Lime Down Solar Park Development Consent Order – Deadline 6 Submissions

Planning Inspectorate Case Reference: EN010168

Removal of Panels from the southern part of Field A1

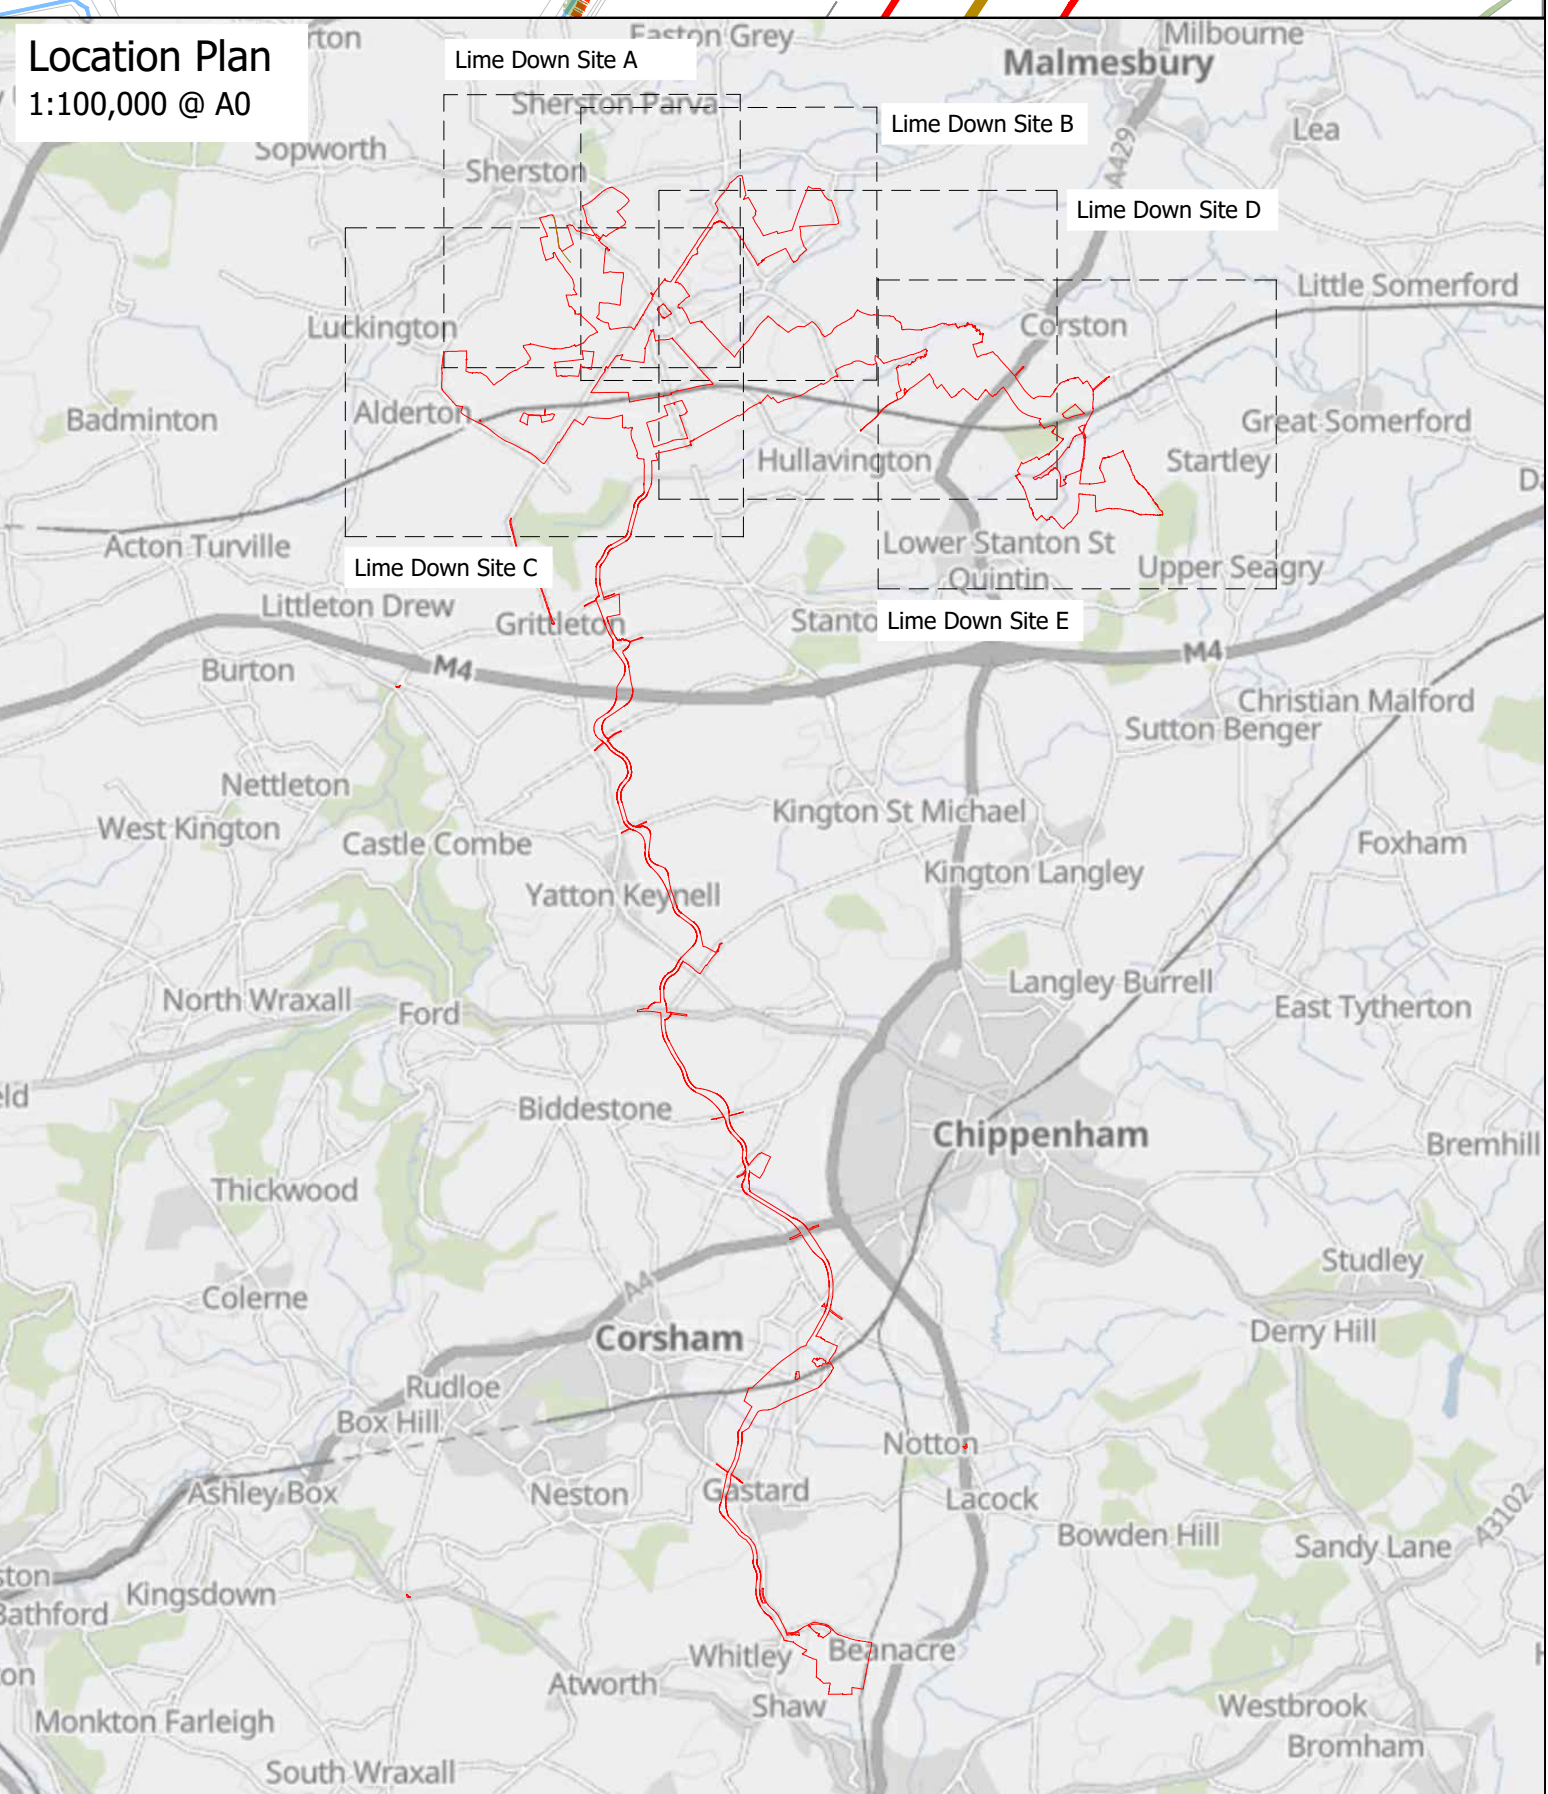
As a result of ongoing engagement with the Cotswold National Landscape (CNL) Board, panels and associated infrastructure have been removed from the southern part of Field A1 and replaced with wildflower meadow. This has also resulted in a small shift of the panels in Field A2 further to the south to accommodate a new hedgerow between Field A1 and A2, and the associated buffer requirements between the A2 panels and that hedgerow.

As a result of the removal of panels from the south of Field A1, the new hedgerow originally proposed between the north and south of A1 has also been removed and associated Biodiversity Net Gain calculations updated. As a result of this change, the following documents are submitted at Deadline 6:

- **Works Plans [EN010168/APP/2.3]** (Revision 5)
- **ES Volume 2, Figure 3-4 Landscape and Ecology Mitigation Plan (Sheet 1) [EN0101/68/APP/6.2]** (Revision 4)
